**Re: Public Exhibition of State Significant Development (SSD10224)
- New Primary School at Edmondson Park**

We refer to the response provided by Liverpool City Council to the State Significant Development Application for the new primary school at Buchan Avenue, Edmondson Park (Lot 1 and 2 DP1257105) and specifically the comments on the landscape design and provide our response as follows.

LA-W-REP-
101-A

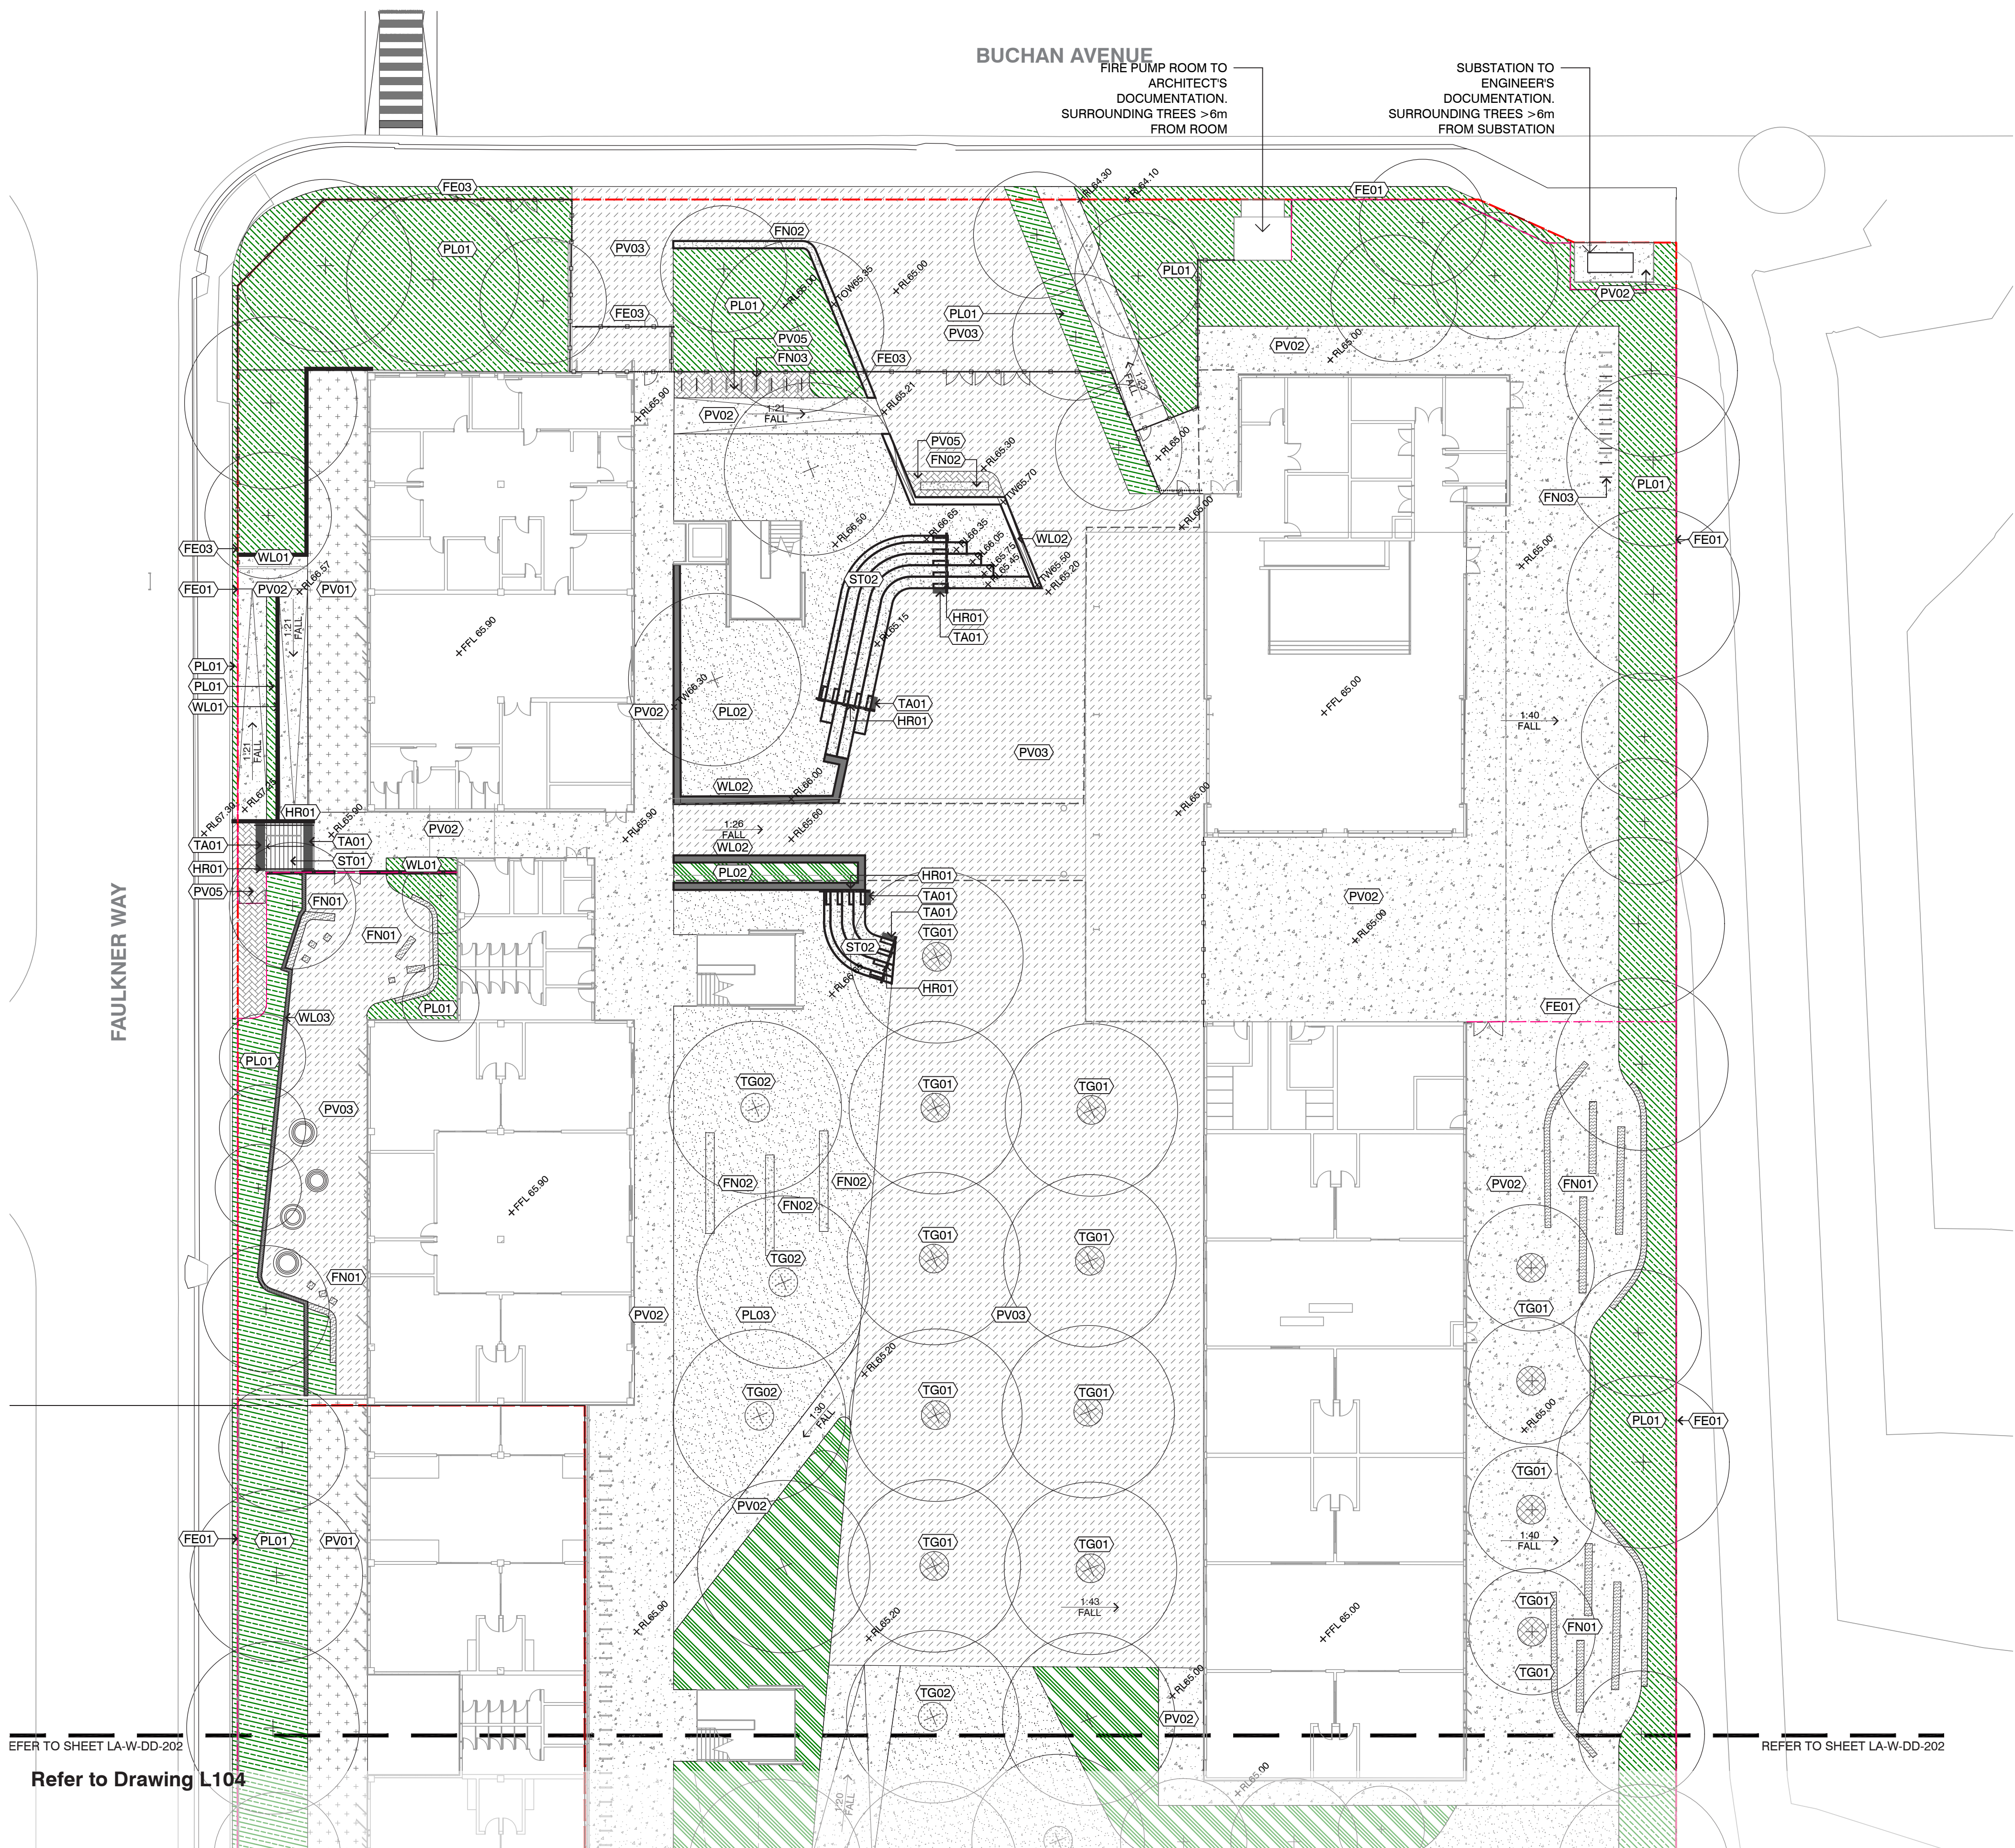
Recommendation: The shape of 'Active Open Recreational Space' should be a more traditional form (i.e., rectangular) to facilitate multiple uses and encourage adaptability for a variety of sports, games, and outdoor activities.

Response: The shape and edges of the active recreational space have been simplified to better accommodate a range of uses and activities. Refer to drawing LA-W-REP- 102-A. However, it is not a SINSW requirement to provide a sports field for primary schools.
